From: Martyn White
Sent: 21 January 2019 17:08
To: Planning.Responses
Cc: Richard Castro-Parker
Subject: BR/320/18/PL & BR/321/18/L

BR/320/18/PL & BR/321/18/L

Planning and Listed building consent is sought for works to create two self-contained flats as well as other works to reinstate lost features. Essentially, the proposal seeks to extend the rear extension of the listed building, along with internal alterations at the ground floor to create a second one bed flat.

PROPOSED ELEVATIONS

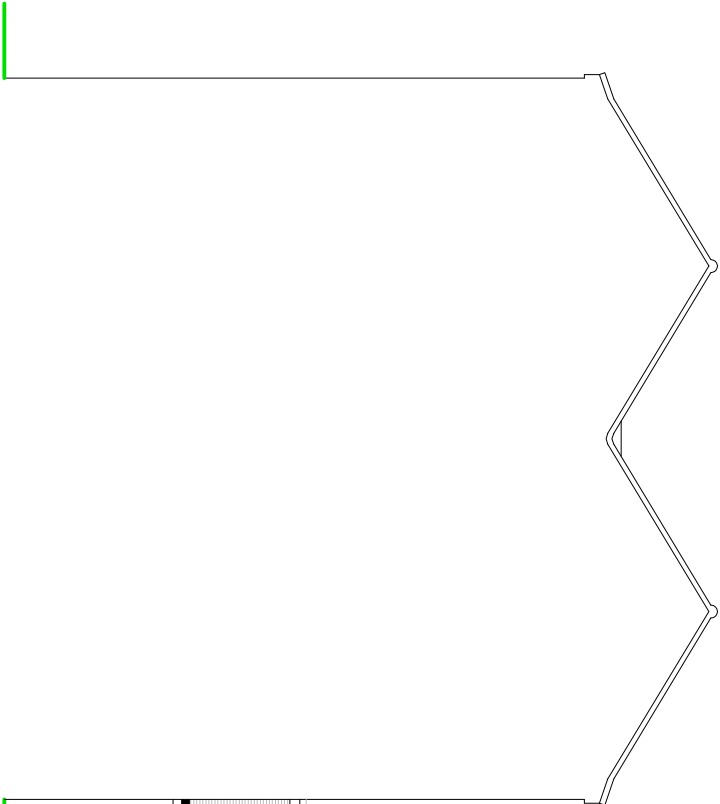
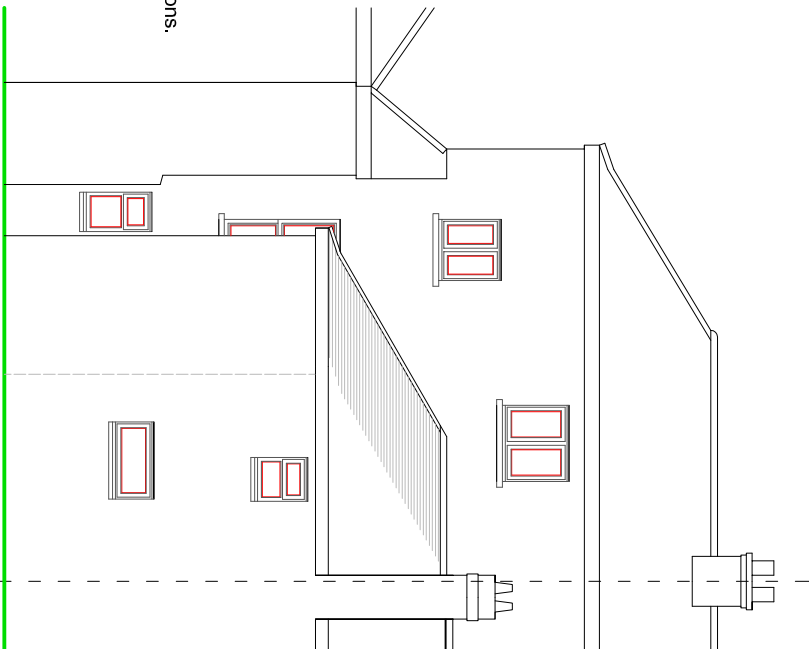
The reinstatement of the canted bay window and details to the projecting first floor balcony are positive as it will lead to the enhancement of the front elevation, and its significance.

No comment is made to the existing inappropriate windows elsewhere within the property. However, new windows should be of an appropriate material and appearance that reflect the status of the building as a listed structure. The windows should be the same colour as the existing ones.

- Details of the railings
- Details of the new windows
